Re: Proposed Wind Energy Development by Ballinlee Green Energy Ltd. – Observation under Section 37E / Planning & Development Act 2000 (Case Number :PAX91.323780

We write as residents Mary and Tom Bulfin V35 DP84. My home is located within 1km of the proposed development by Ballinlee Green Energy Ltd. Case number 323780. I lodge this observation to draw attention to a number of concerns regarding the proposal and to request that An Bord Pleanála give full consideration to the issues outlined below.

Figure 15-3: Wind Turbine and Dwelling Locations

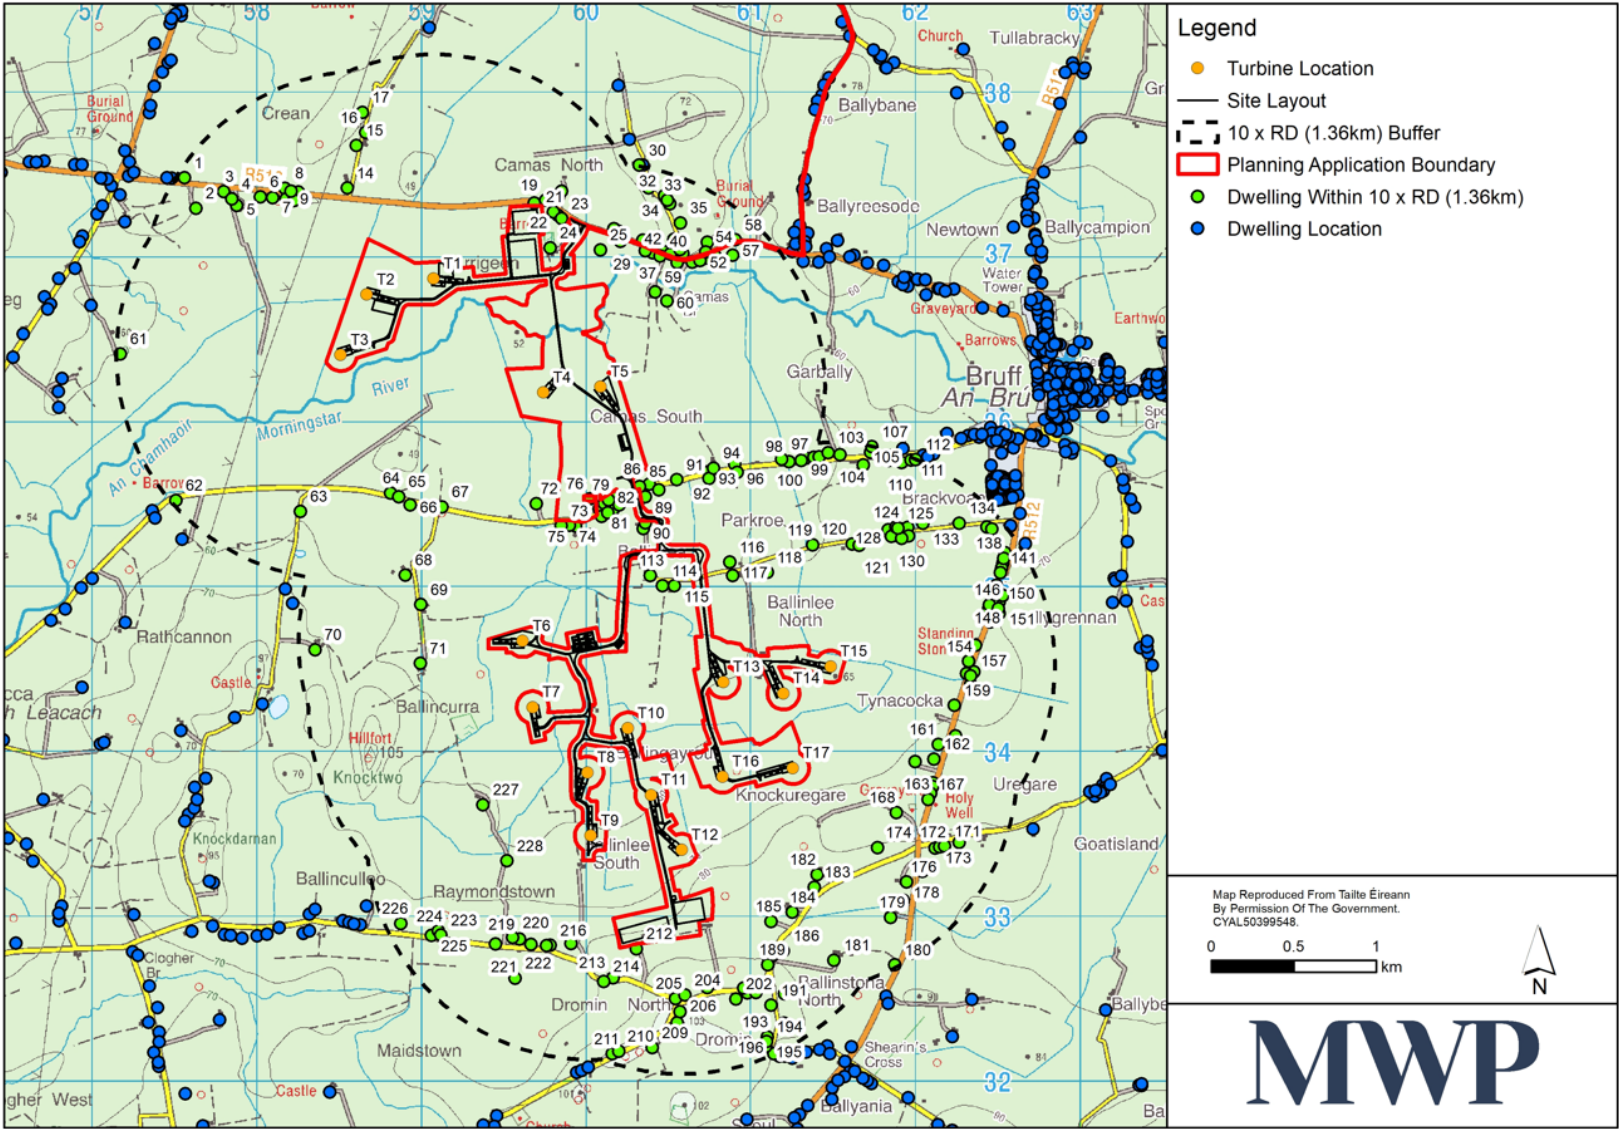
- Our property lies just 1 km from turbine T2, with the applicant's own data showing **up to 127 days per year** and **36 minutes per day** of potential shadow flicker.
- This clearly **exceeds the limits** in the *Wind Energy Development Guidelines (2006)*, which recommend that shadow flicker should **not exceed 30 minutes per day or 30 hours per year** at any dwelling.

- Based on the figures provided (36 minutes × 127 days = over 76 hours per year), the proposal **breaches the existing national threshold**.
- Furthermore, the **Draft Revised Wind Energy Development Guidelines (2019)** propose a **zero-tolerance policy** for shadow flicker at existing dwellings, confirming that such exposure would be unacceptable.
- The turbine's proximity (1 km) may also fall within the "10 rotor diameters" distance where flicker risk remains significant for modern turbines with rotor diameters of 100–160 m.
- Shadow flicker:
 - The 2006 Wind Energy Development guidelines established that shadow-flicker at neighboring dwellings should not exceed 30 hours per year or 30 minutes per day.

· Our house is dwelling No. 5 shown above in green.
